BLANNING AMENDMENT

H09/0615/00

CHALET BUNGALOW AND
DETACHED GARAGE

Amendment: Alterations to dormer windows and eastern elevation, plus
details of materials

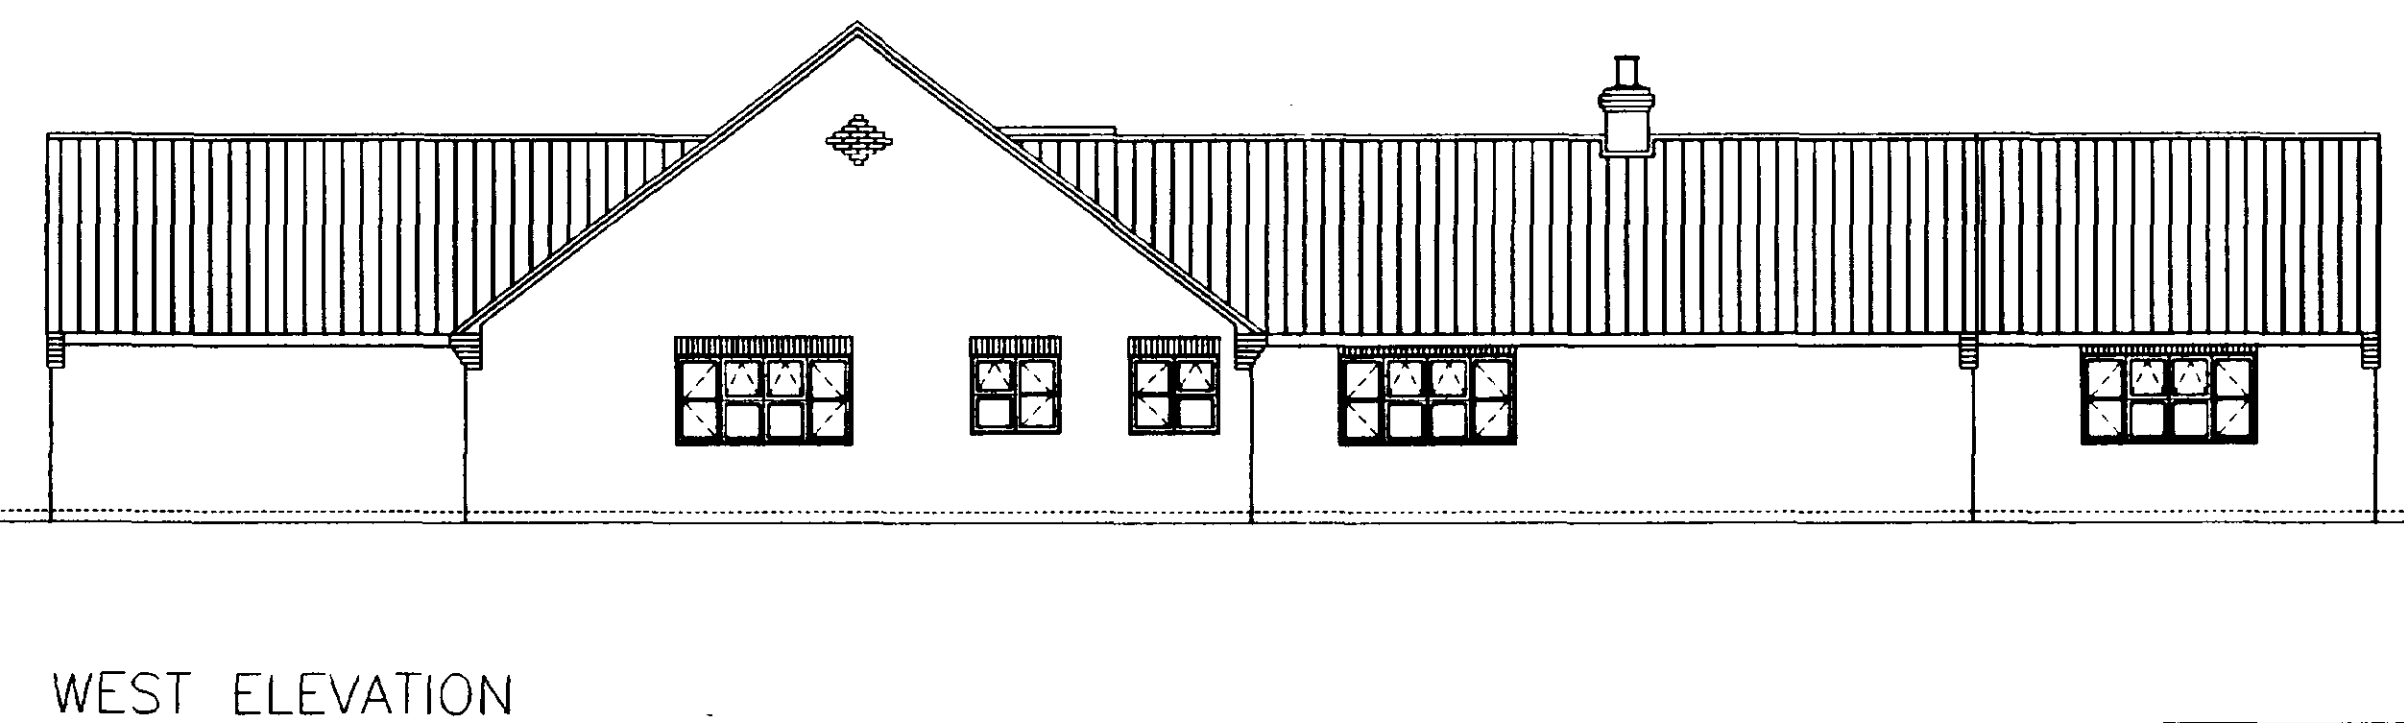
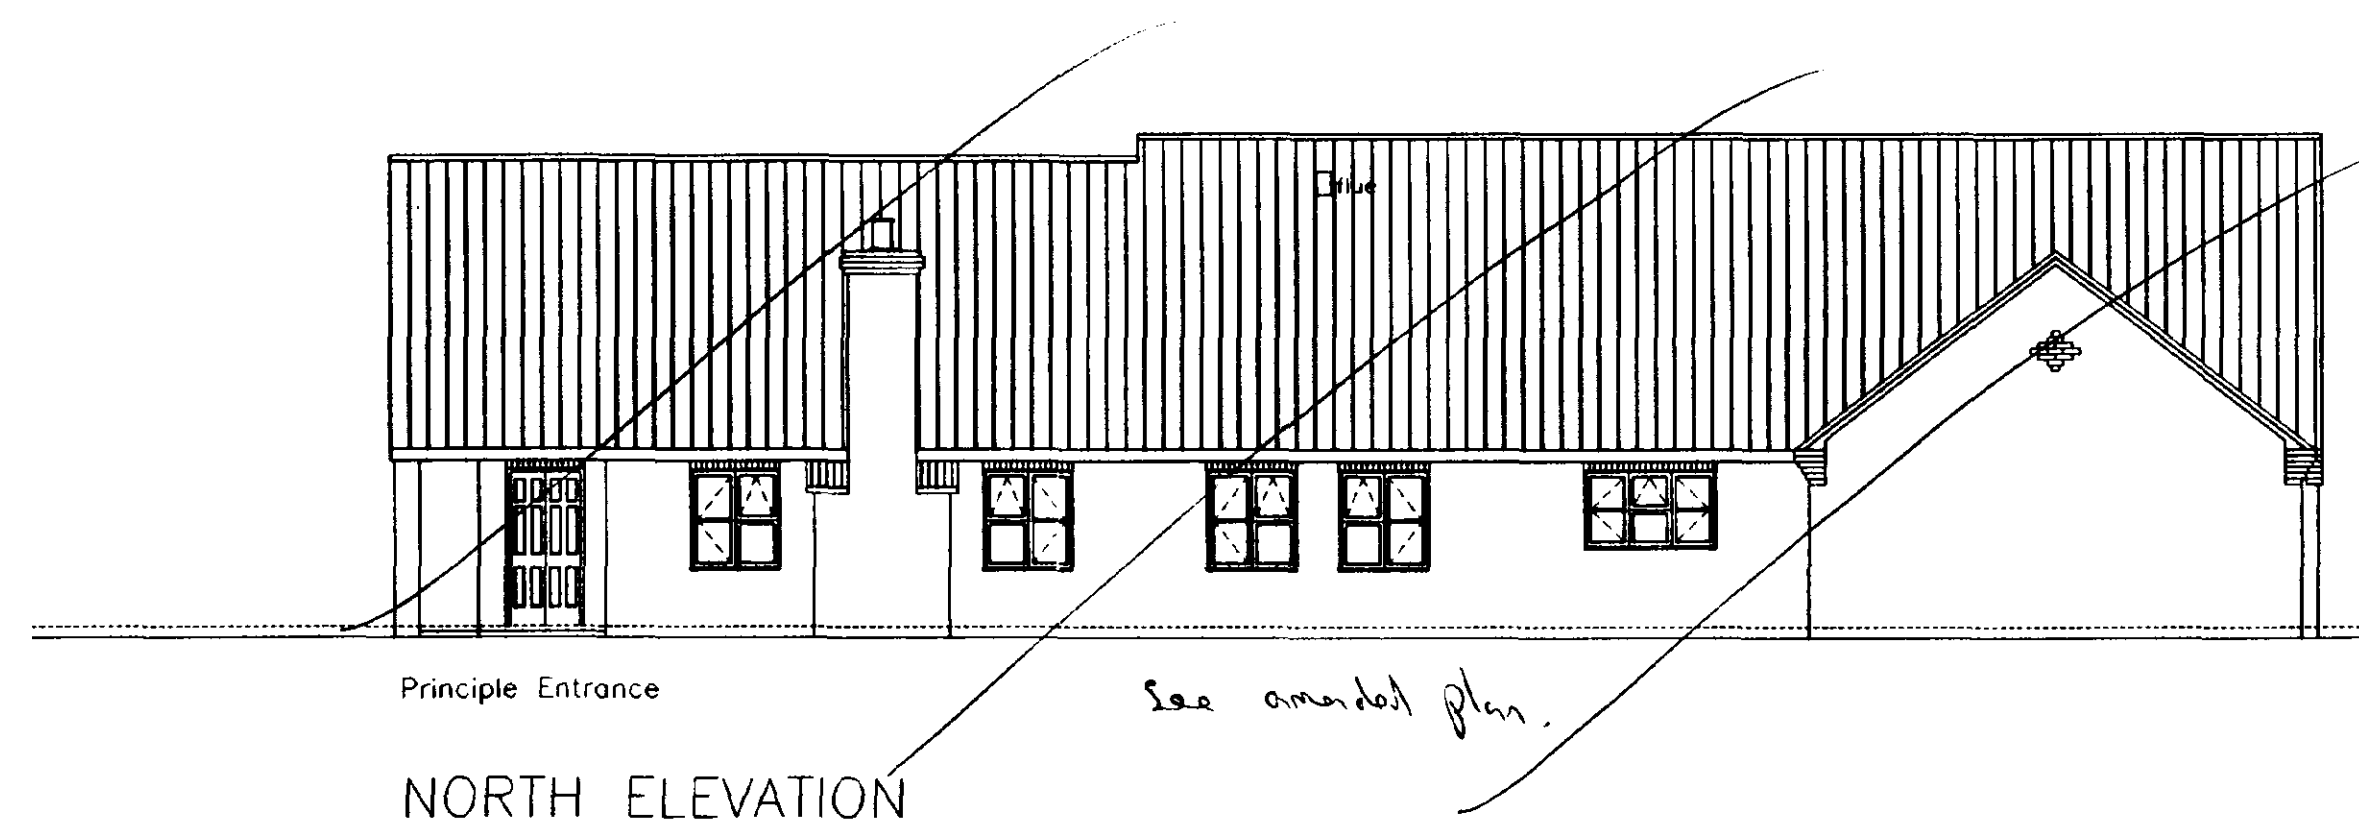
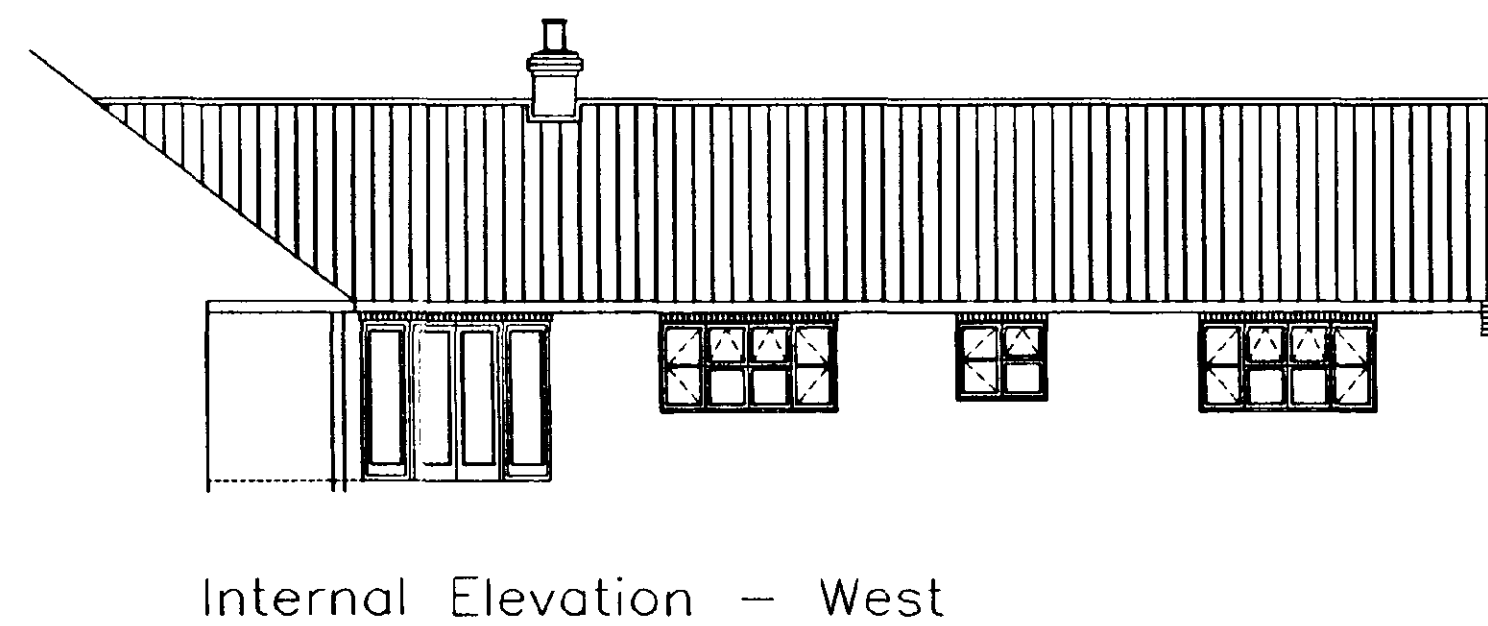
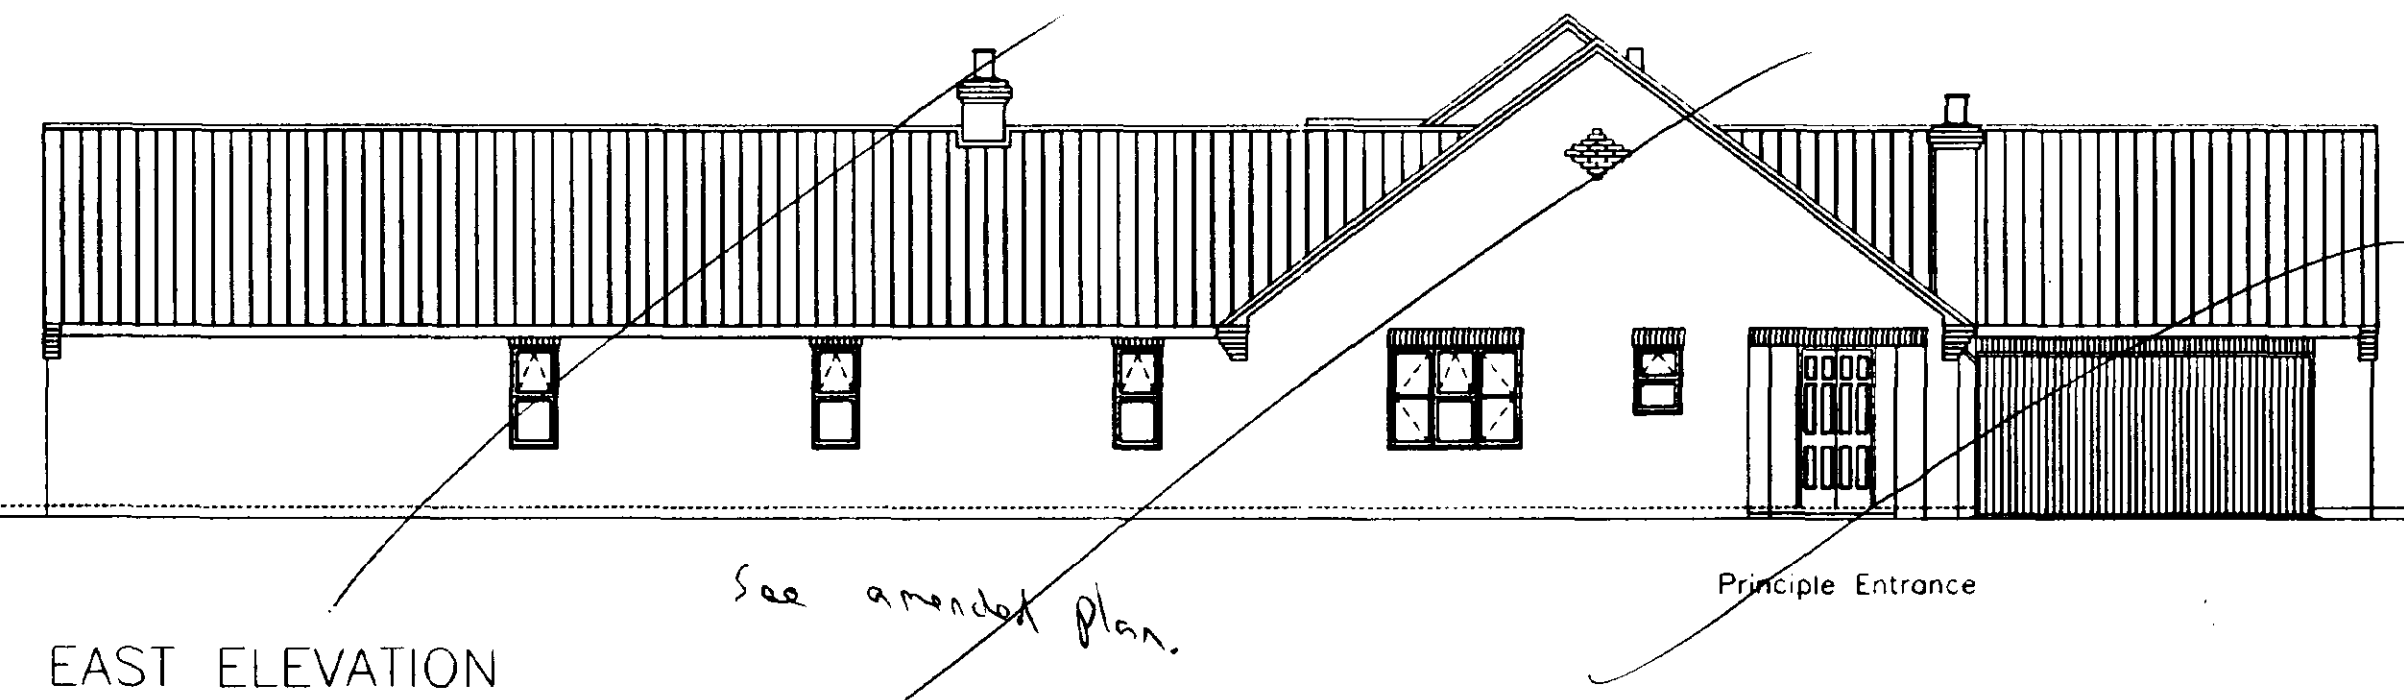
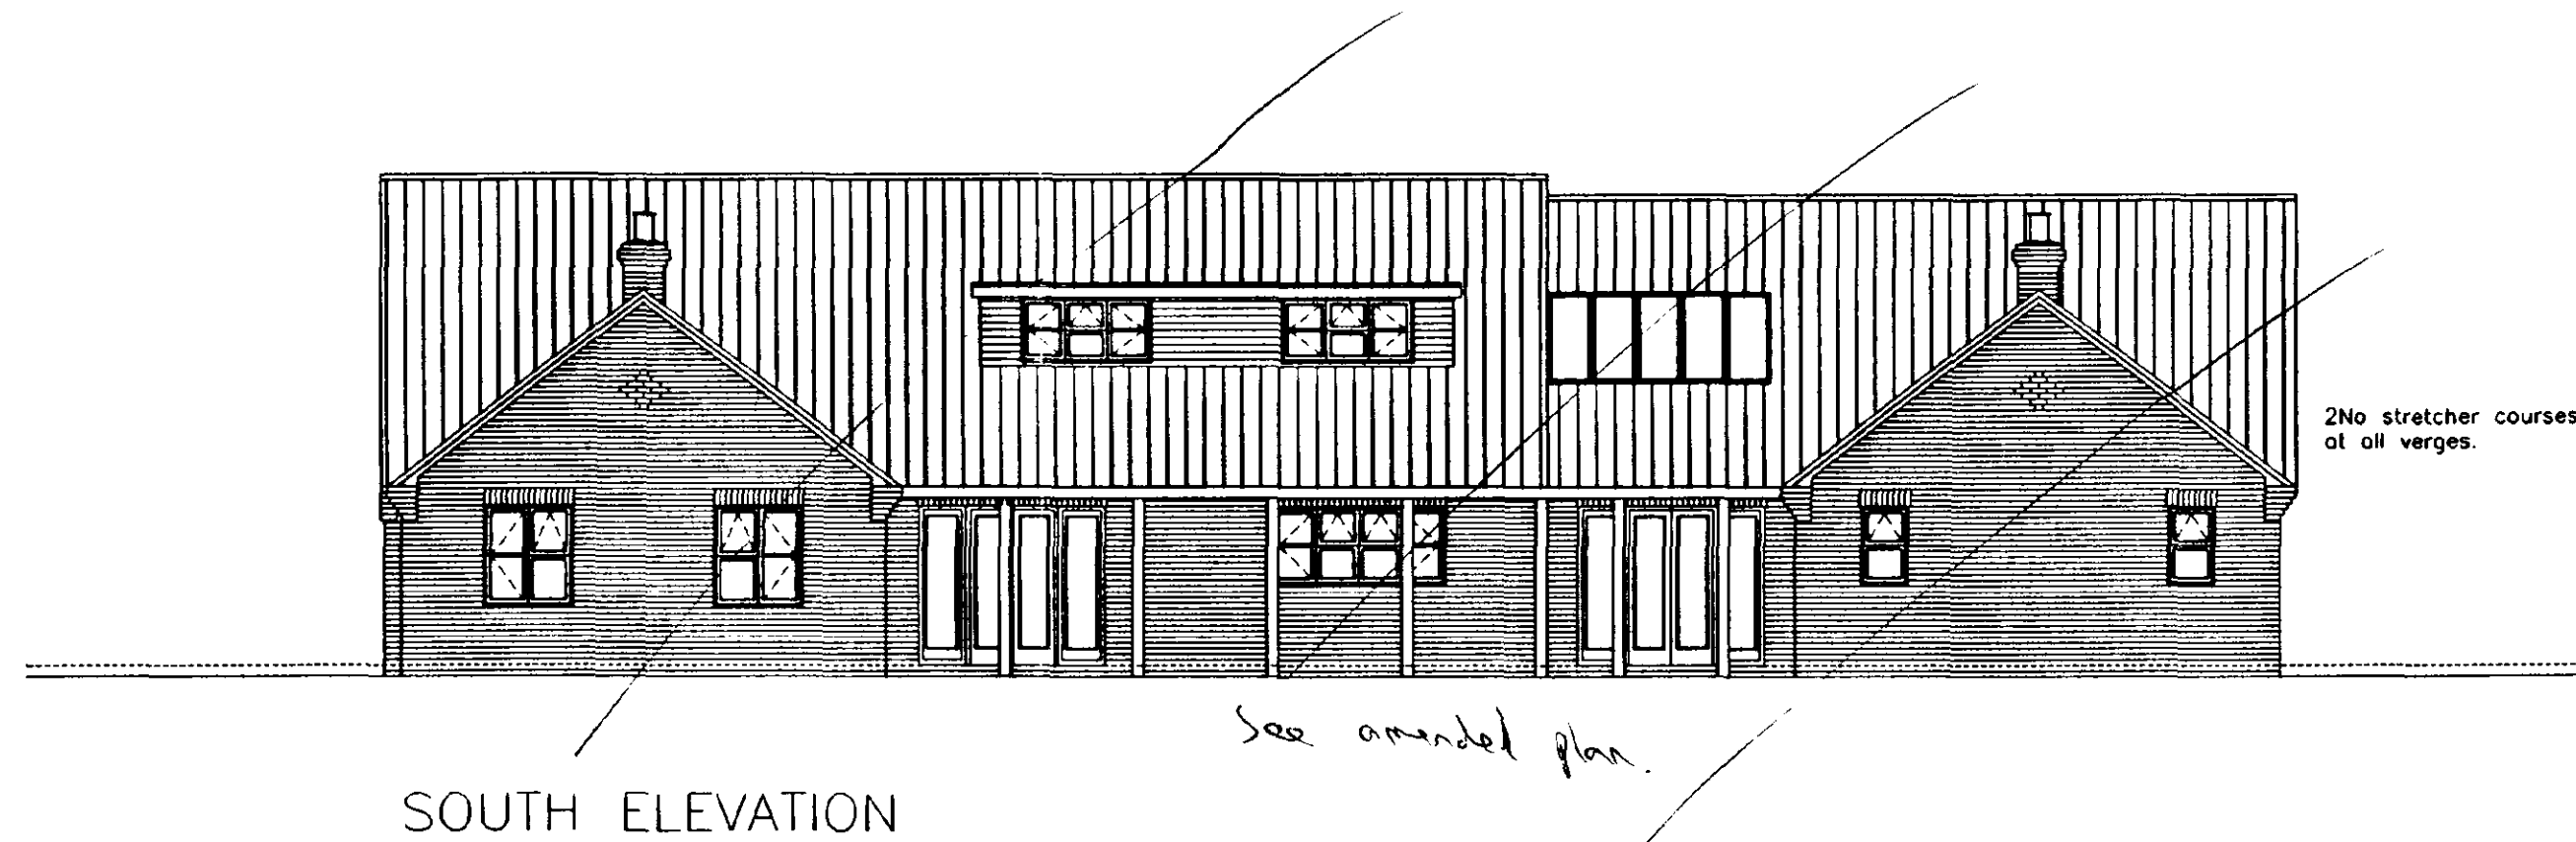
(A) 2 N^o PITCHED ROOF DORMER WINDOWS INTRODUCED IN LIEU OF CONTINUOUS FLAT ROOF DORMER, ON SOUTH ELEVATION
(B) GABLE END ON EAST ELEVATION EXTENDED OUT 225 MM
(C) VELUX ROOF LIGHT INTRODUCED ON NORTH ELEVATION
(D) EXTERNAL MATERIAL PROPOSALS SUBMITTED
FACE BLK: YORK HANDMADE OLD CAMP
ROOF TILES: CROMLEIGH WELSH BLUE SLATE BY HARRIS
2939-001 B + AMENDED ALL ELEVATIONS
STATE & VELUX
